TfNSW reference: STH22/00345

Your reference: SSD-24262975 / PAE-50357968

**SSD-24262975 – Proposed New K-12 Educational Establishment – LOT 76 DP751159 –
Corner of Lignum Road and Kiely Road, MOAMA**

Transport for NSW (TfNSW) is responding to the SSD-24262975 referred on 8 November 2022.

Figure 8: Pedestrian and cycling connections

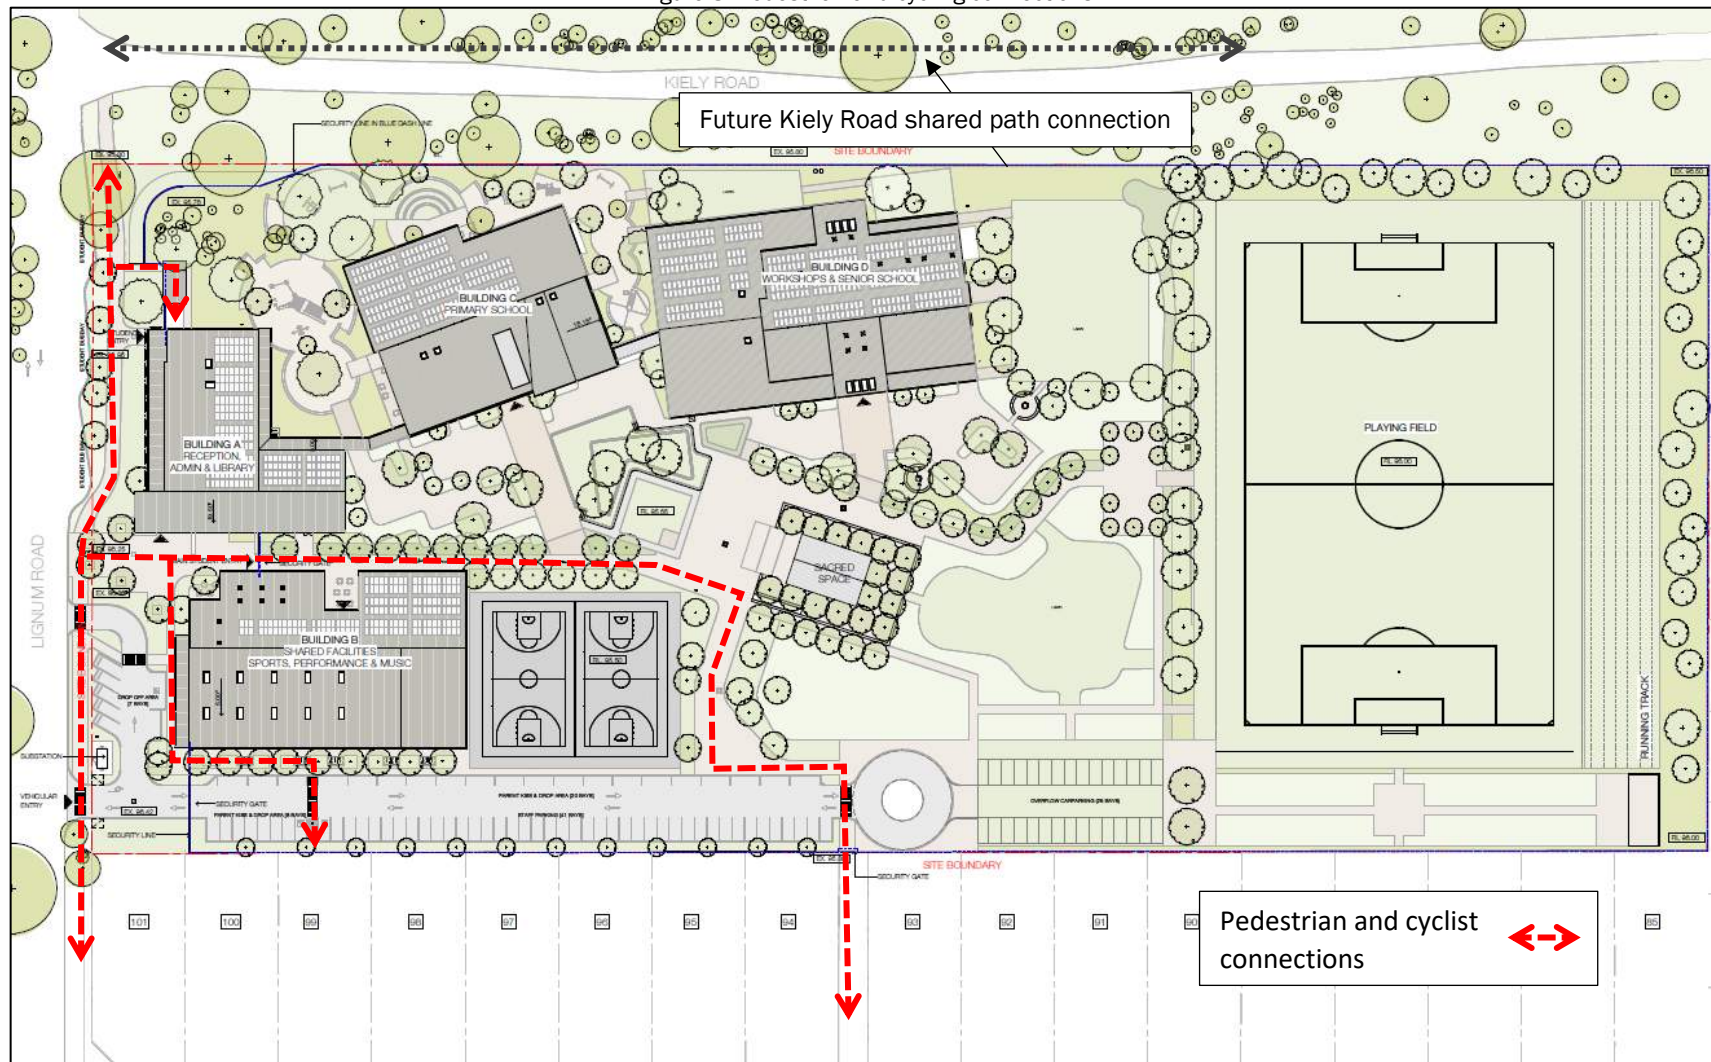
- Consideration should also be given to active travel routes including safe pedestrian crossings to assist students who live east of the Cobb Highway to travel to the proposed college. TfNSW notes the existing crossing to the north of the intersection of the Cobb Highway with Boyes Street / Nicholas Drive.

Figure A1: Site Plan

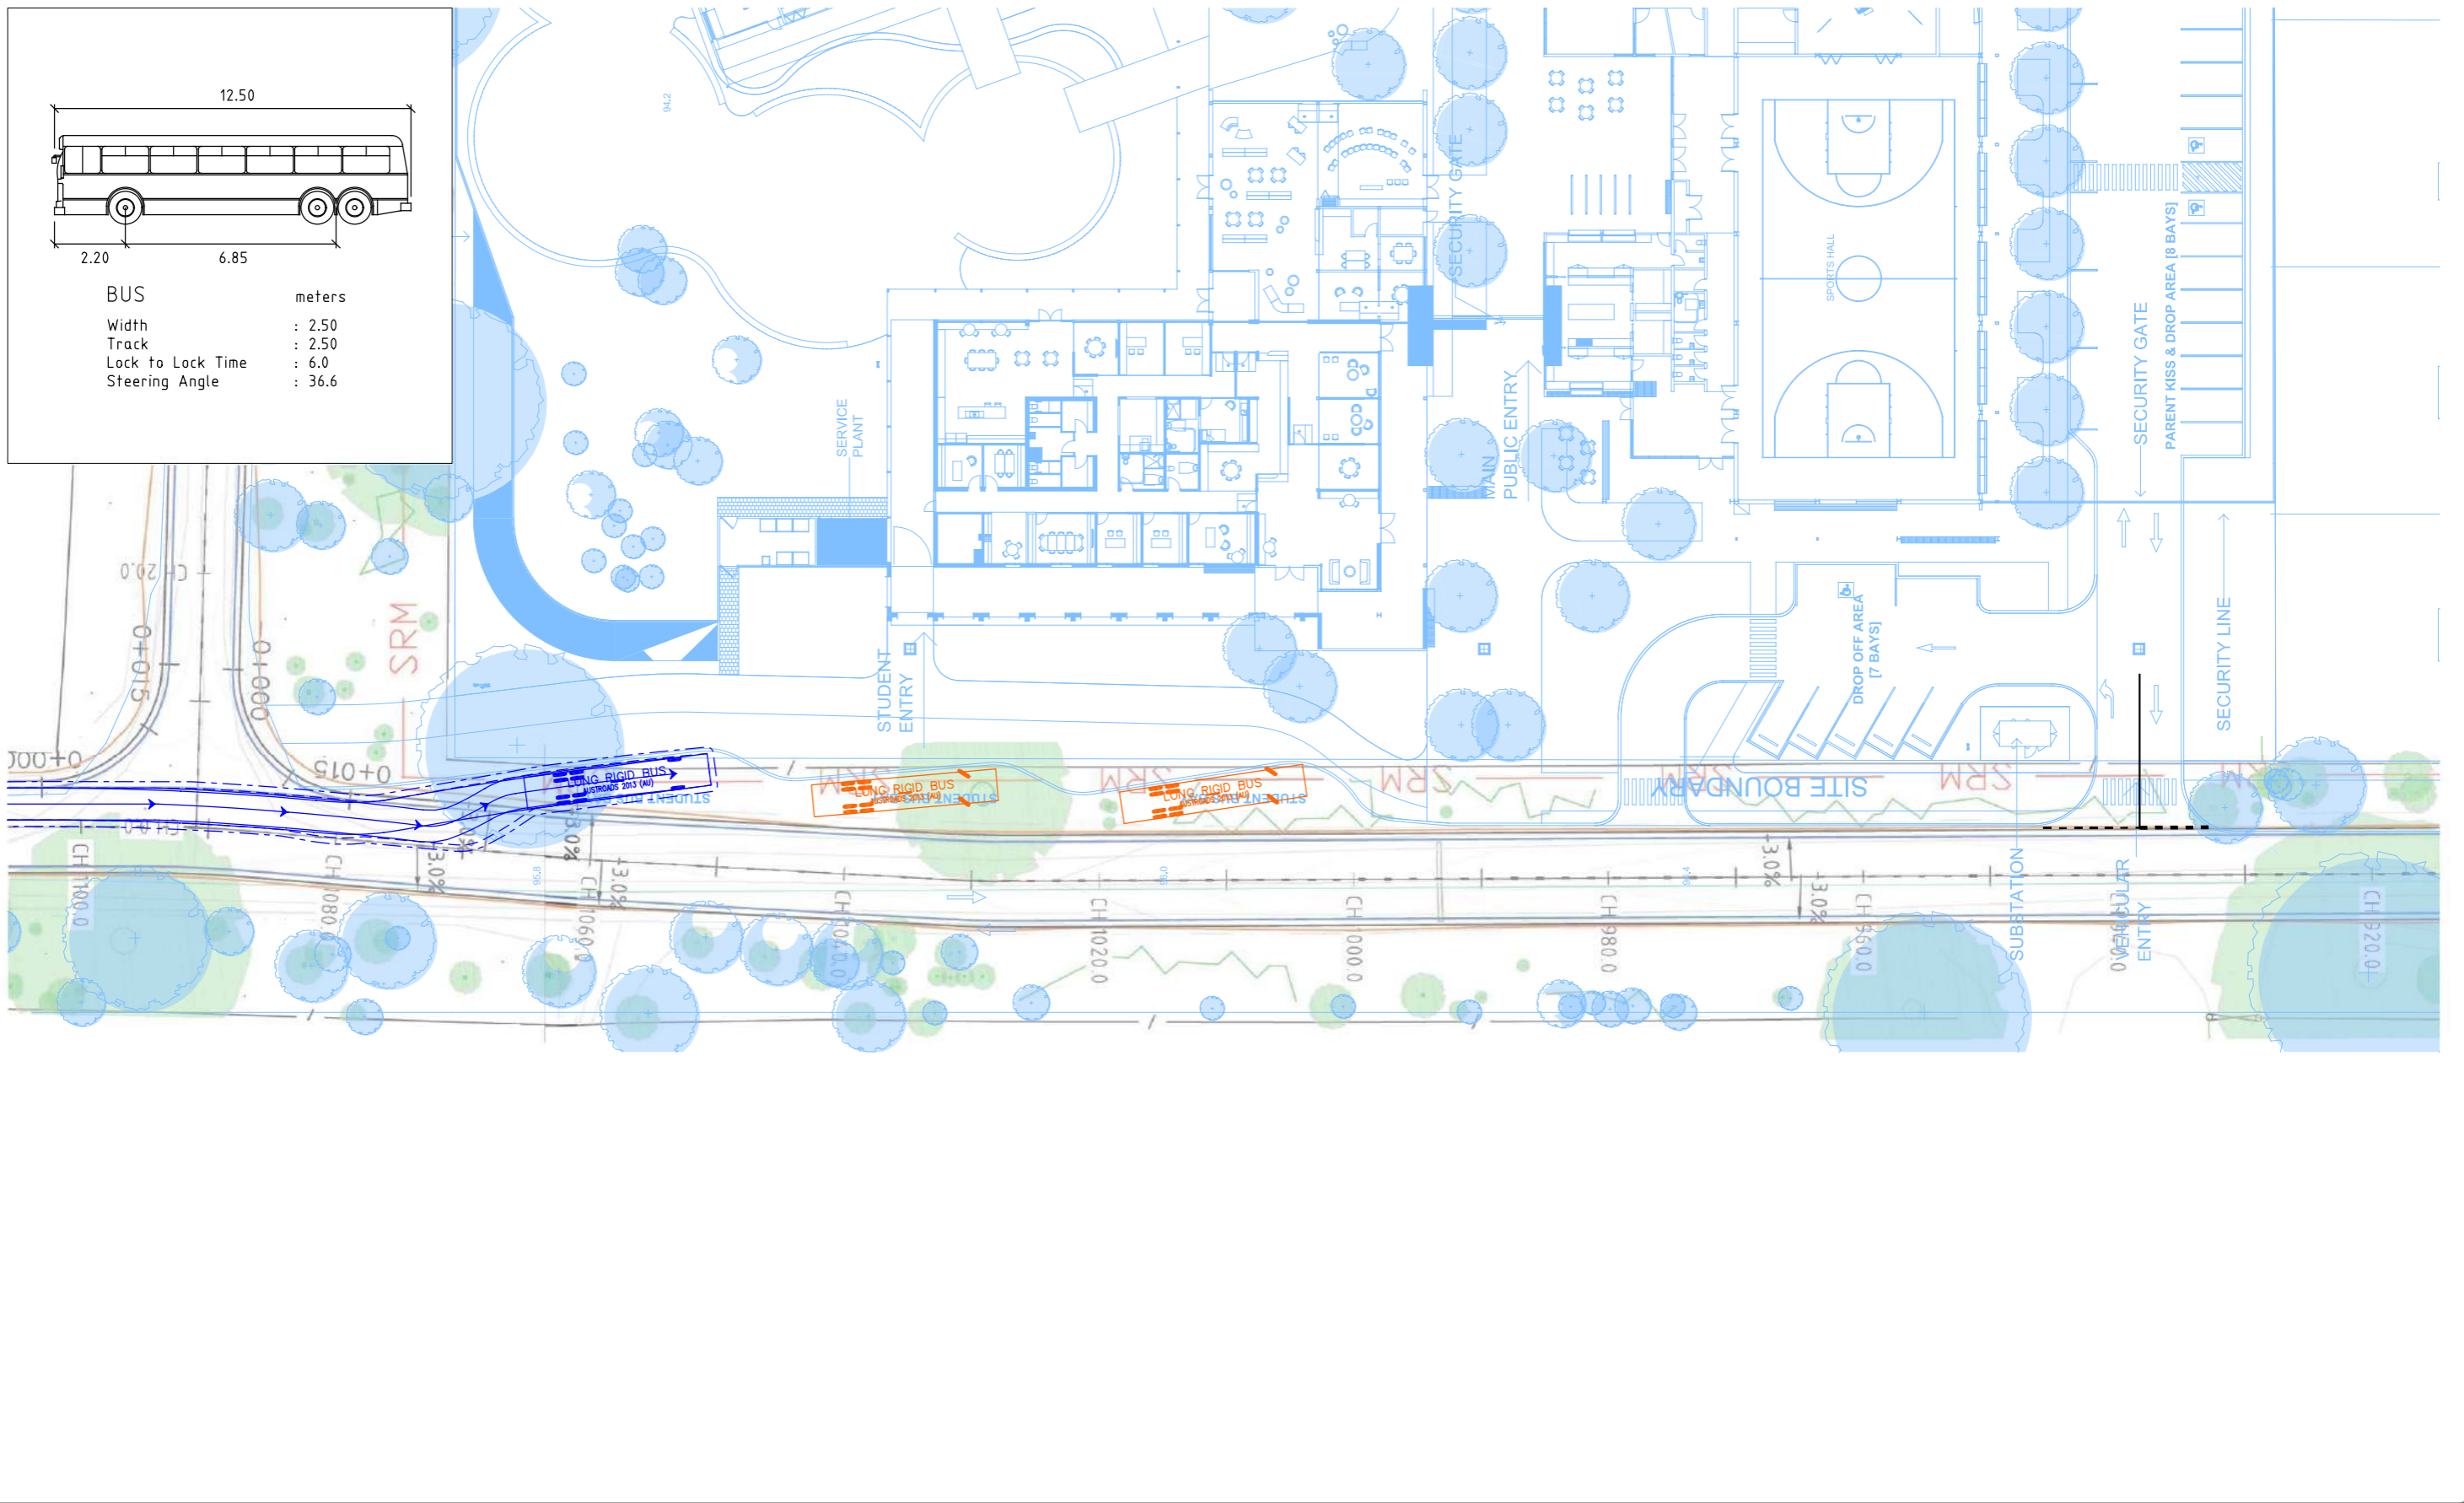
- d The approved school zone shall be maintained in accordance with approvals issued by TfNSW for the life of the development.
2. The indented bus bays on Lignum Road shall comply with Austroads Guide to Road Design (2021) Part 3: Geometric Design (refer to Figure 4.63). Before finalising the indented bus bay design contact shall be made with the TfNSW Rural and Regional Contracts team (Tanya Jennison, Commercial Manager Southern Region – 4253 2683) to discuss the number of buses required to service the site and the suitability of the indented bus bay (e.g. its length to cater for the required/determined number of buses).
